203 Fore Street - preliminary comments

Below are some preliminary review comments.

SITE PLAN LEVEL 01 - FORE STREET  
1/16" = 1'-0"

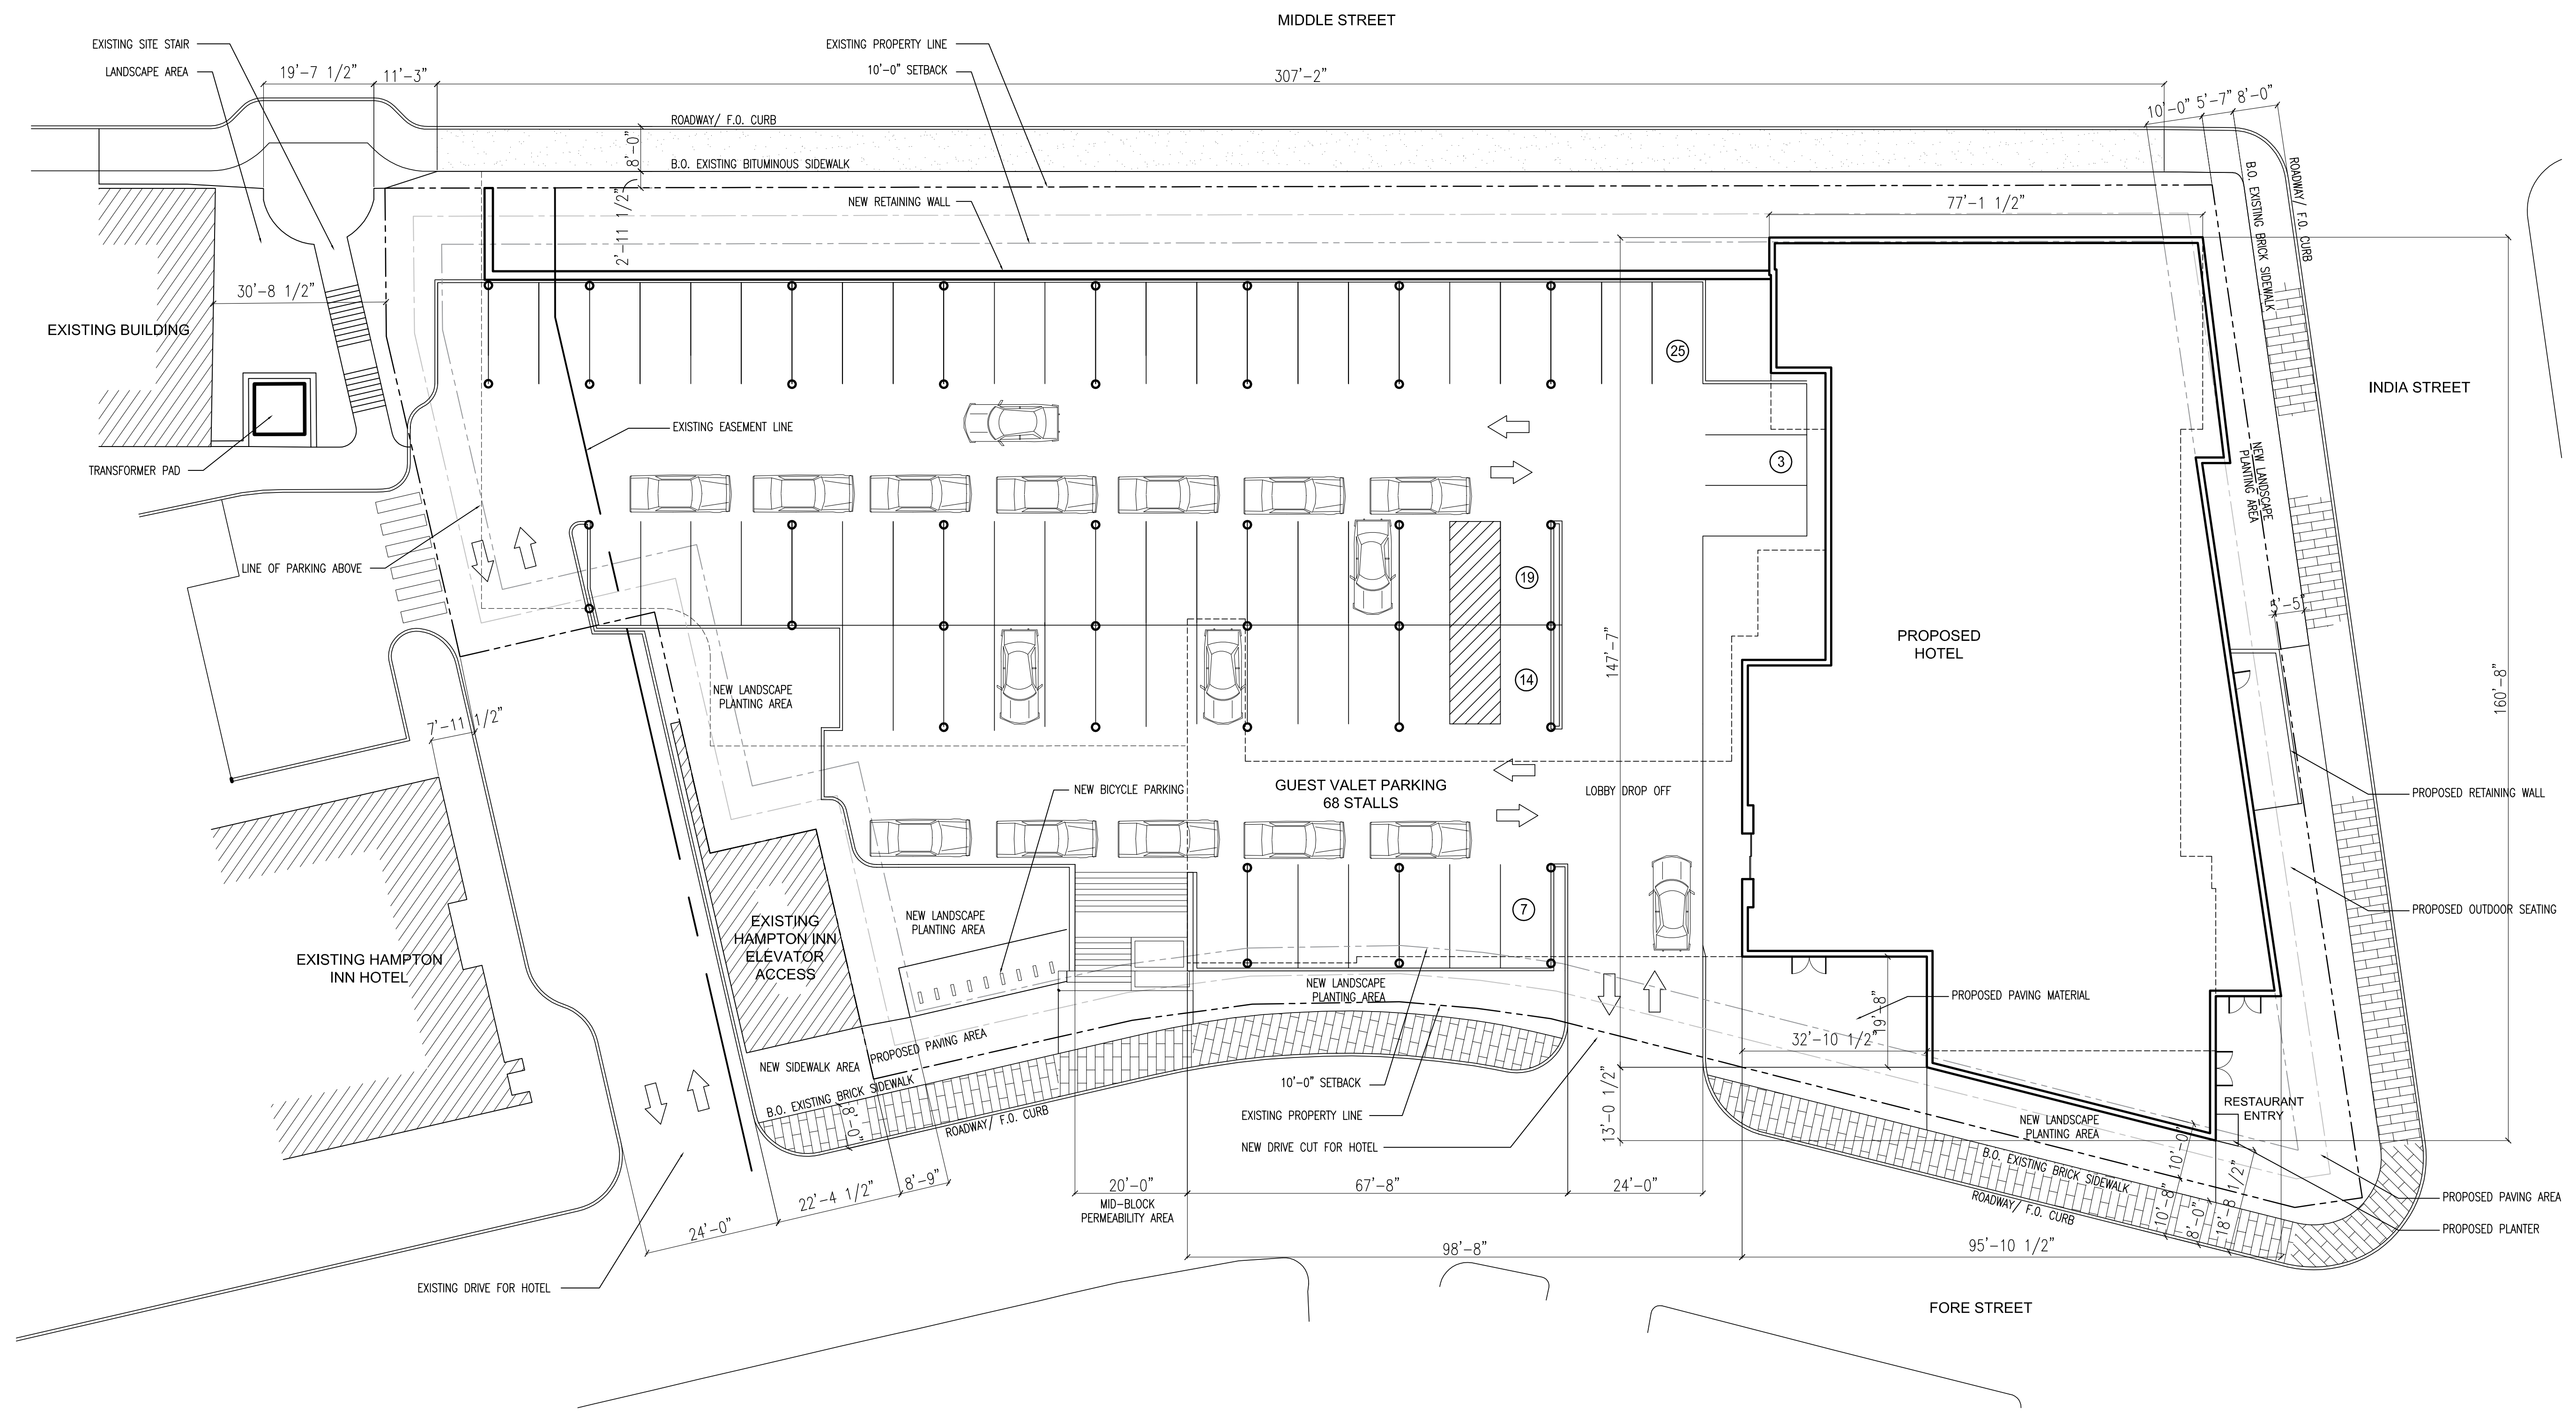
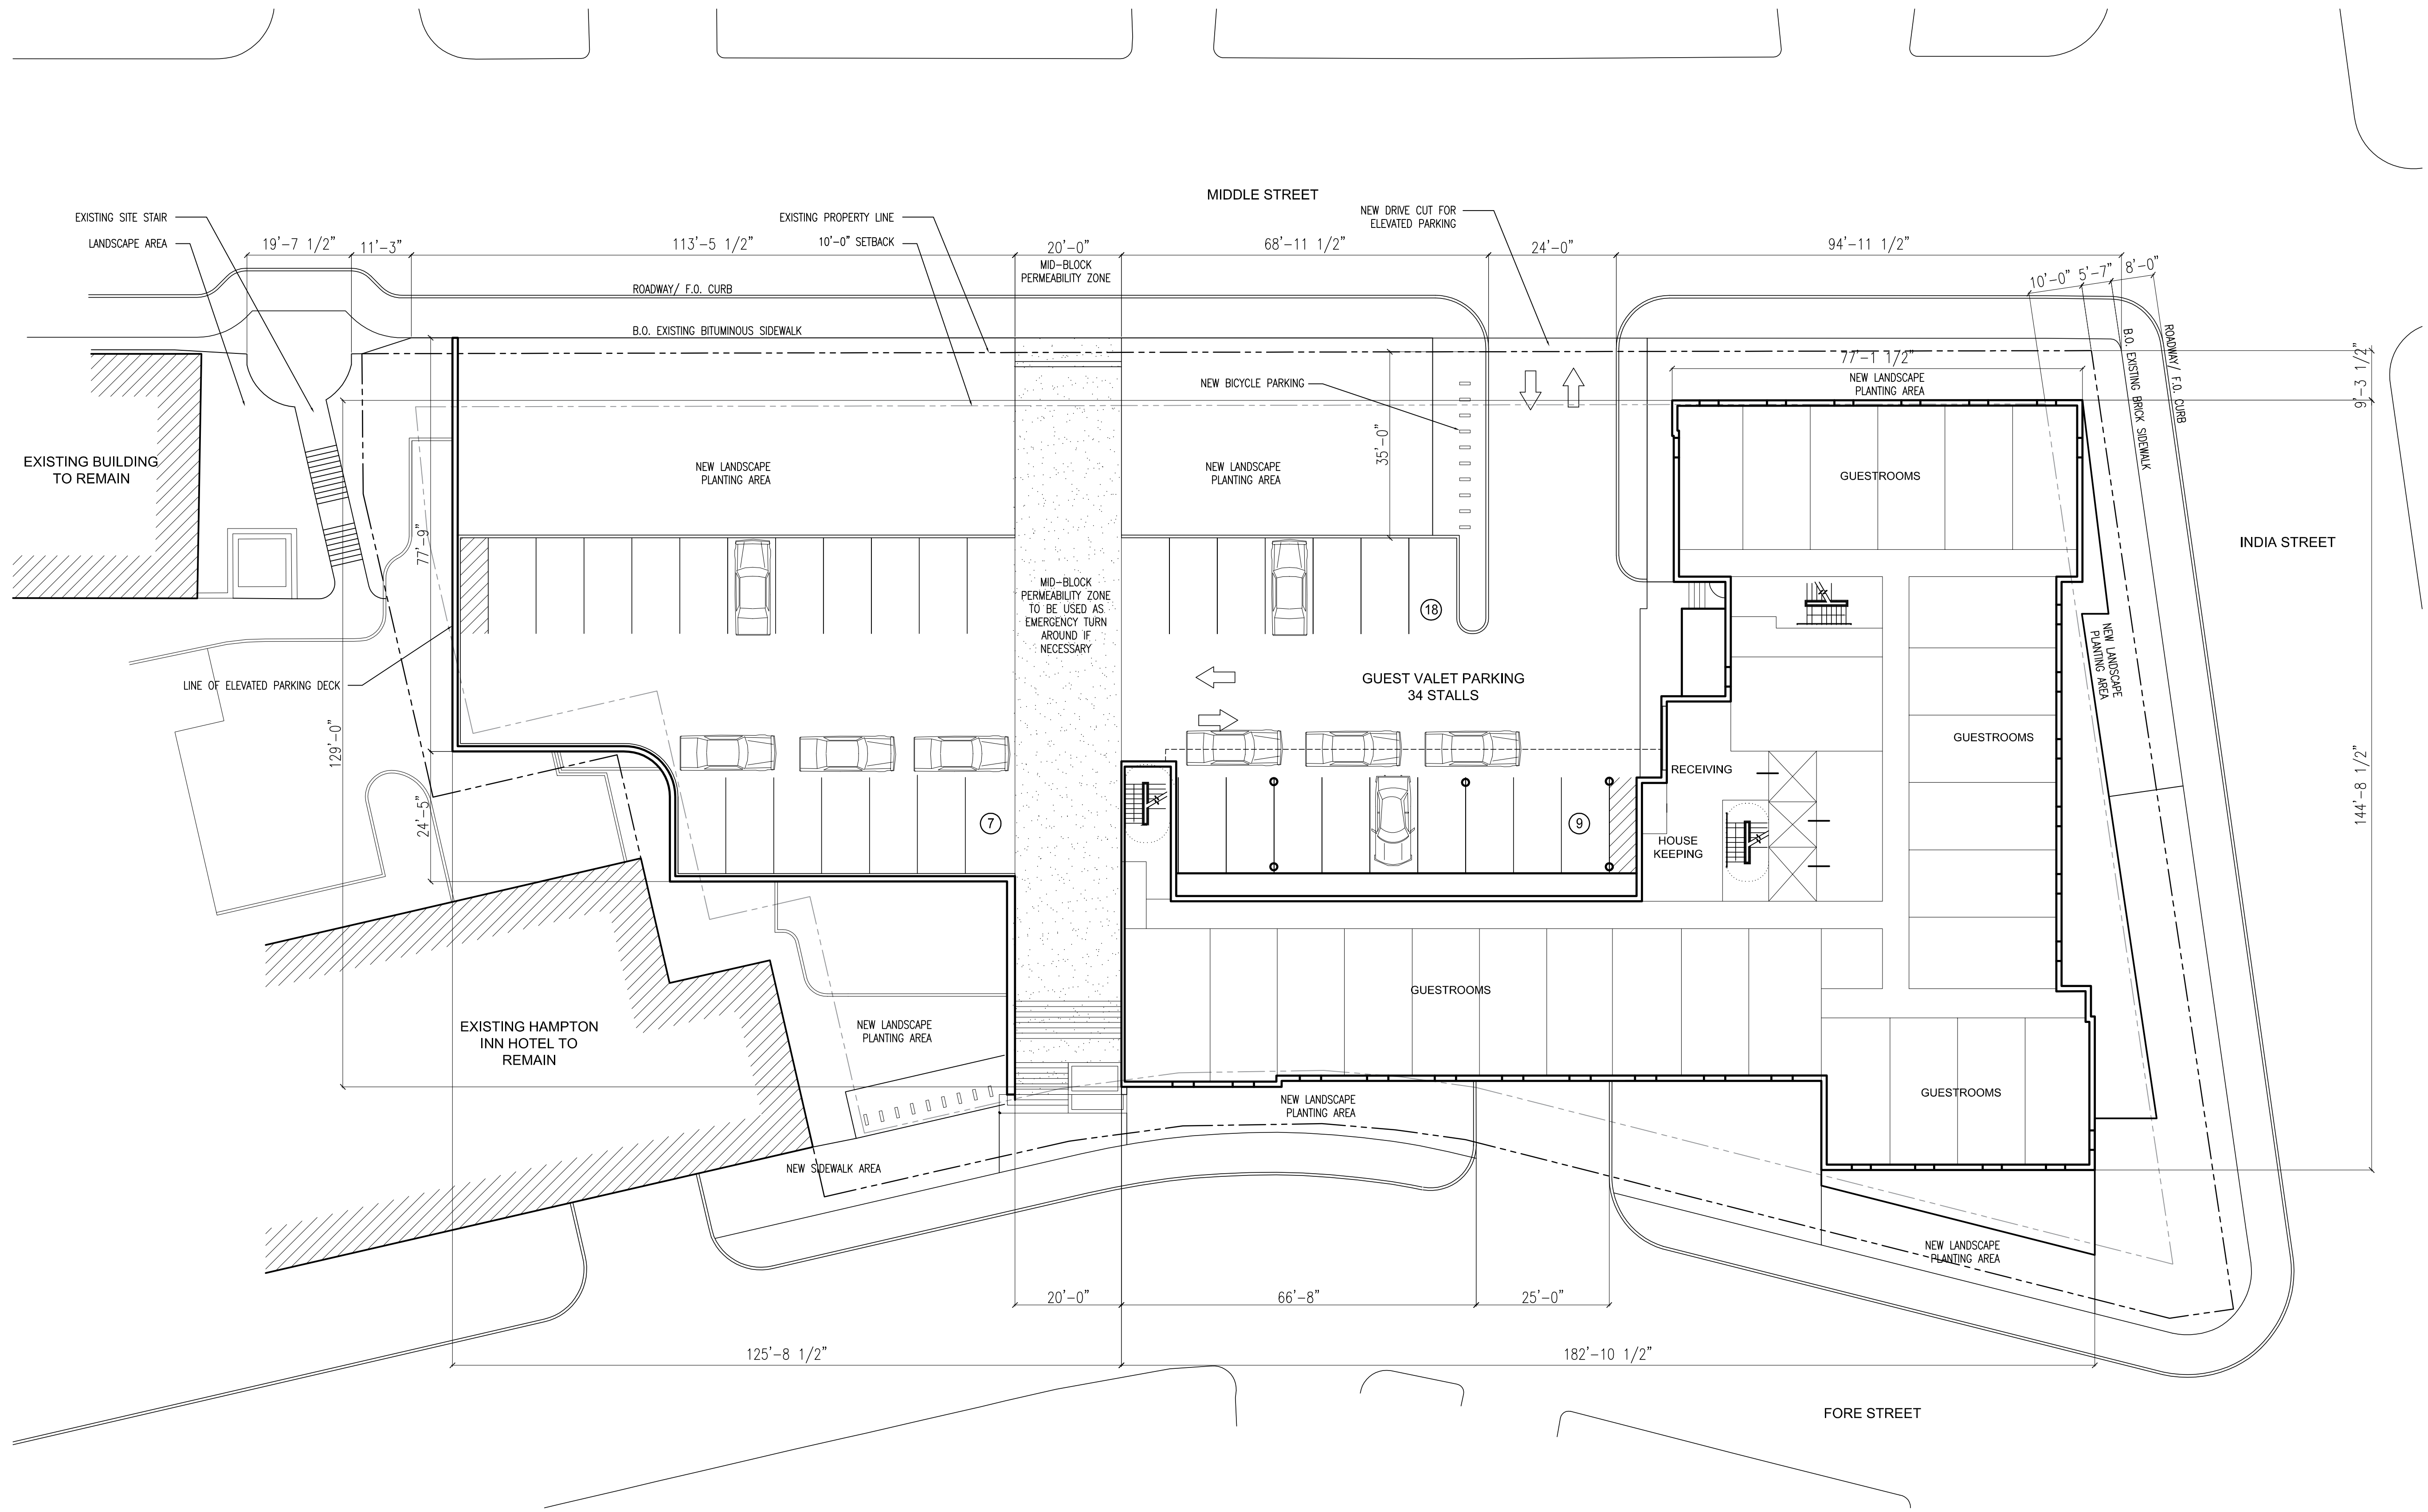
- The project is proposing two driveways (one on Middle Street and one on Fore Street). The number of driveways complies with City Technical standards. I would note that the driveways will reduce the number of on-street parking spaces along both streets and thus consideration of narrowing driveway widths may be beneficial.
- I investigated the location of driveways as it relates to corner clearance and both appear to meet City standards.
- The project will need to provide details on truck deliveries.
- The project will need to provide a parking demand/supply analysis and how parking will be managed between the proposed hotel and Hampton Inn.

- Parking lot dimensions are not provided, so I can't offer feedback on parking layout.
- It will be important that the mid-block walkway be designed to optimize pedestrian safety and minimize vehicle conflict.

NORTH ELEVATION  
1/8" = 1'-0"

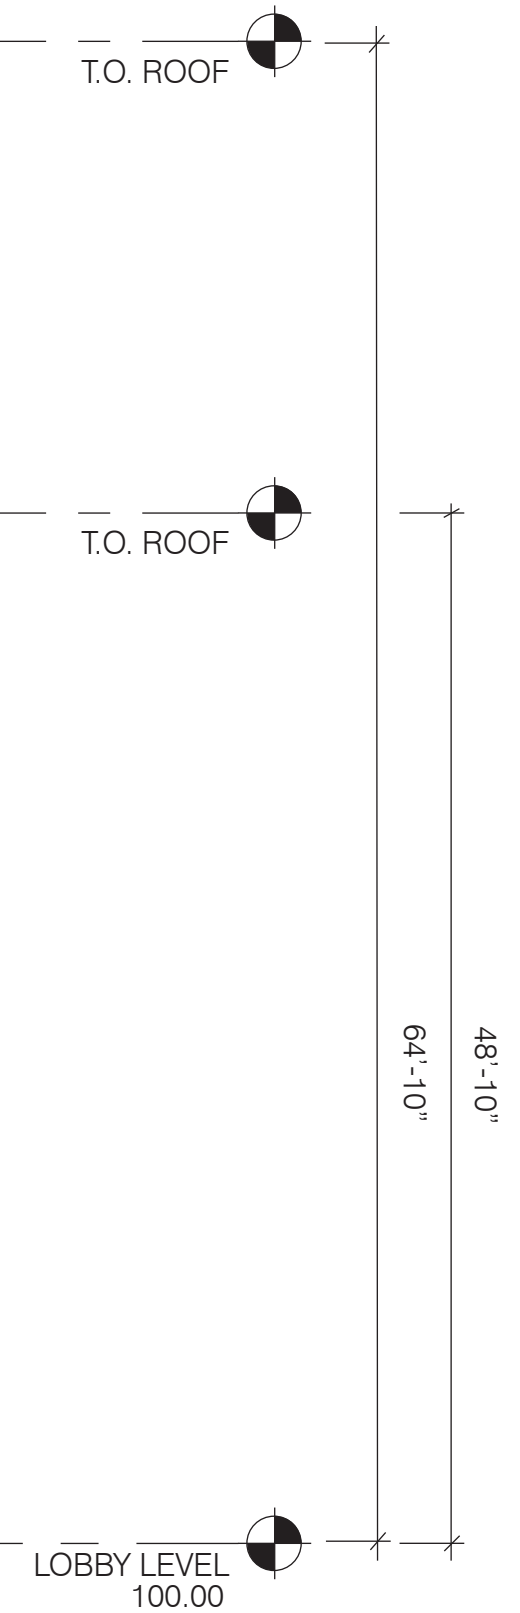
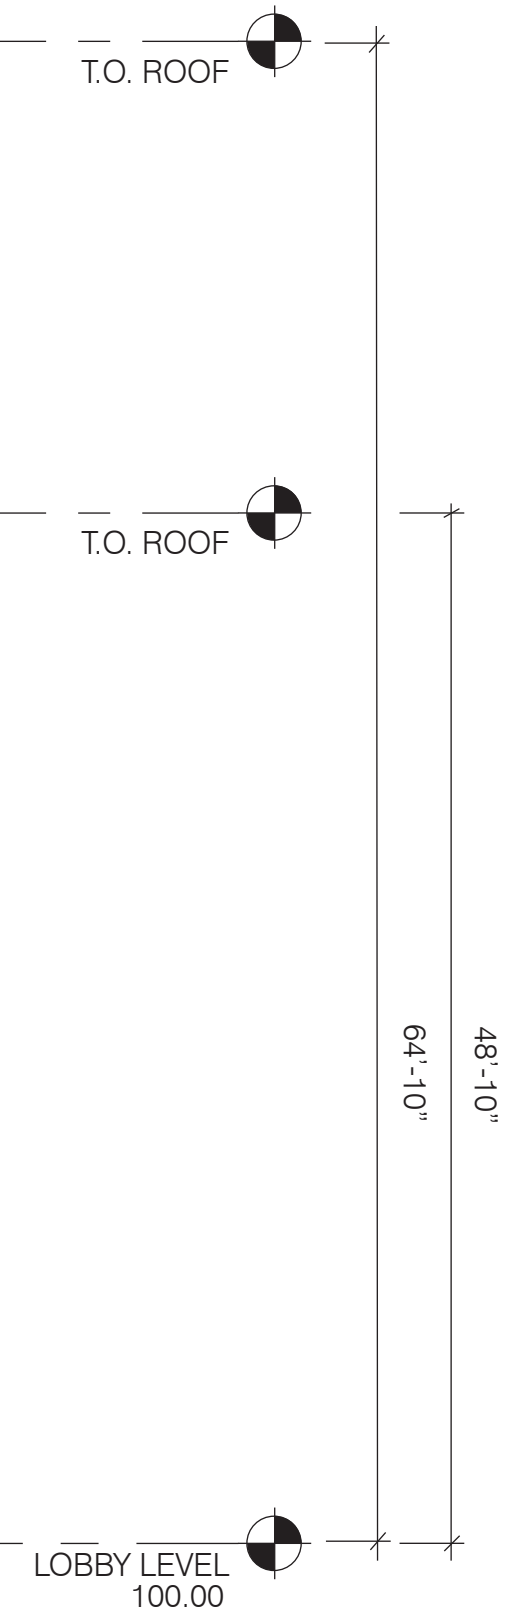
- building length (max) - India Street max is 150', and several waivers will need to be granted in order for this elevation to be allowed 150' in length
- building length (max) - Middle Street max is 50', right now there is no apparent methodology applied to this elevation to allow additional building length (up to 150')
- Front yard setback (max) - the Fore Street facade does not meet the 75% requirement to be within 10' of the street. However, the revised IS-FBC zone does state that the building length maximum requirement takes precedence over the max yard setback requirement if they are in conflict.
